RESPONSE TO EXAMINERS QUESTION 2.13.5  
On behalf of  
**GREENSFORGE SAILING CLUB**

In respect of  
Application for Development Consent Order for  
**West Midlands Interchange**  
By Four Ashes Ltd

**Response to Examiners Additional Question 2.13.5**

Figure 2b: Building heights modeled in this analysis. (Left Side: Configuration 2; Right side: Configuration 3)

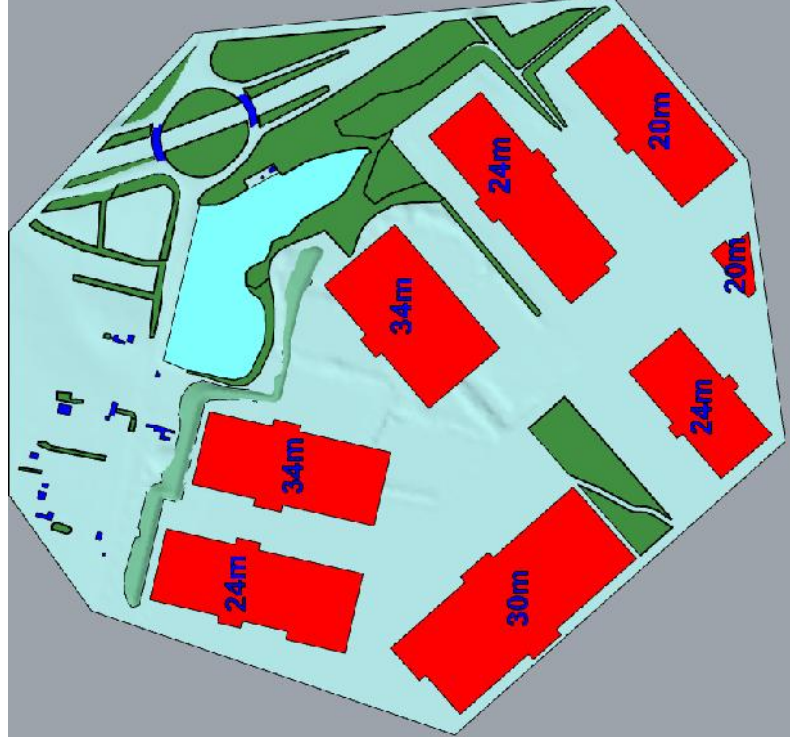
- 2.28 It is noted that in the RWDI report, building heights of 34m have been utilised, with the applicant advising the Club that this figure was used in the model “*to ensure there was a conservative bias adopted in the assessment.*” (see post meeting note in Appendix 1). The Club note that the height selected for the RWDI assessment outweighs that identified in the parameters plan. Such an approach effectively deflects the wind at a greater height, and this will result in dispersed impacts on the leeward side. Consequently, this approach generates a result which favours the applicants’ assertions.

Figure 7 Configuration 2 (DEVELOPMENT OPTION A): Sailing Quality (%)

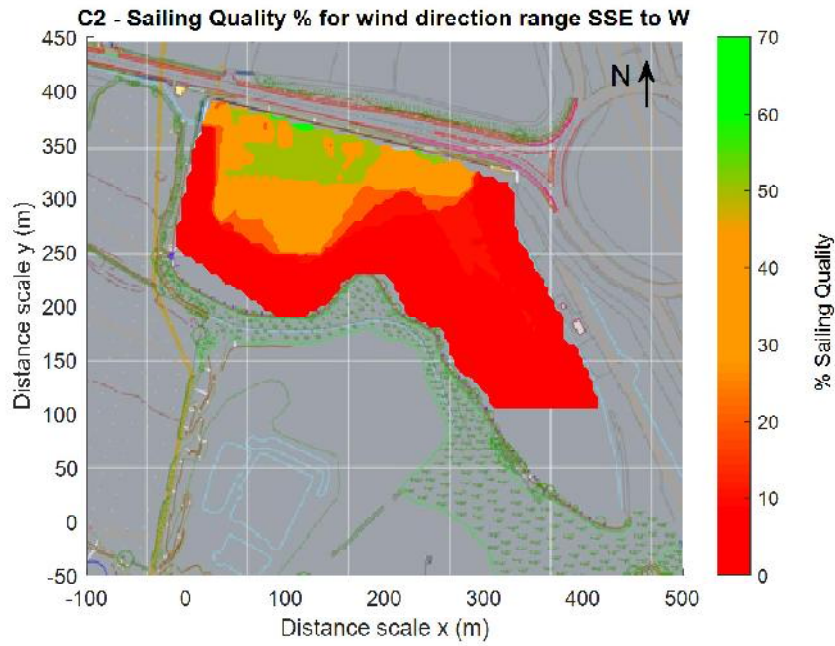
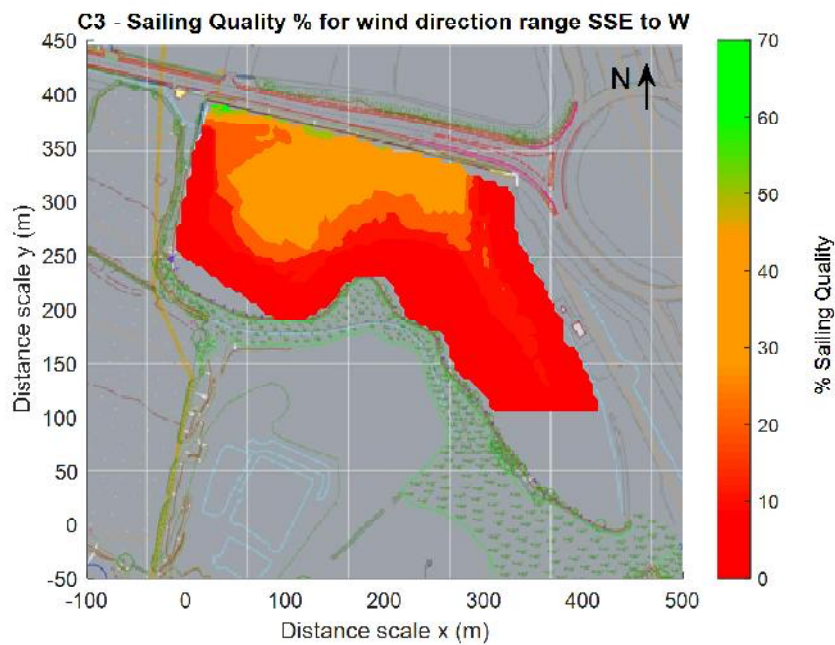
- 2.37 The Wolfson Unit report determines that a 15% reduction in sailing quality (as determined by wind speed, changes in wind speed between specific locations, and direction) is deemed as having a ‘significant’ impact.
- 2.38 It is noted that the assessment calculates/scores conditions under the two tested scenarios as 16.5% and 15.6% respectively. The differences in these scores are identified as being 3.2% and 4.1%, although this does not identify the proportional reduction in sailing quality, which is calculated as follows:
